Proposal: Variation of Condition 4 of planning permission ref. 21/03450/F to replace the words "in limewashed rubble stone" with "in a 50/50 mix of natural ironstone and natural limestone" (proposed as non-material amendment to 21/03450/F)

- 2.1. The application seeks approval as a non-material amendment for a variation to the condition relating to the stone sample panel, to substitute the requirement of a limewash finish with a 50/50 mix of ironstone and limestone. The description of development has been amended, including the planning permission to which this application, in consultation with the applicant's agent.

**South Elevation BR**

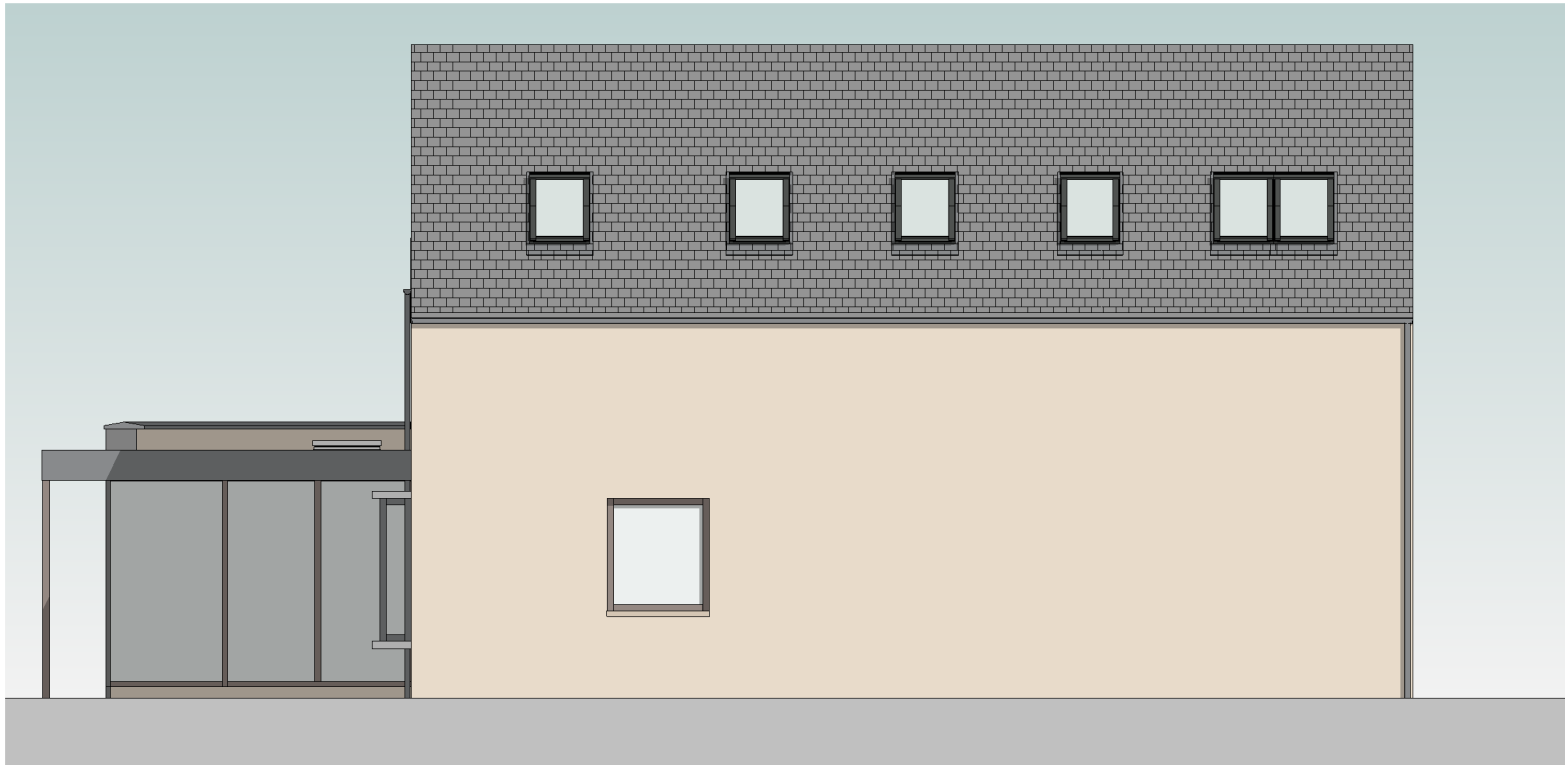
- 5.4. It is considered that the use of natural stone without a limewash finish is more appropriate in this location and the material itself (natural stone) is not changing. The condition as currently worded does not explicitly require the use of ironstone; however, Condition 3 requires a schedule of all externally facing materials. There is local precedent for the use of a mix of ironstone and limestone within the elevations of buildings and it on balance it is considered that a 50/50 mix here is acceptable and does not raise any new issues for the assessment of the planning application.
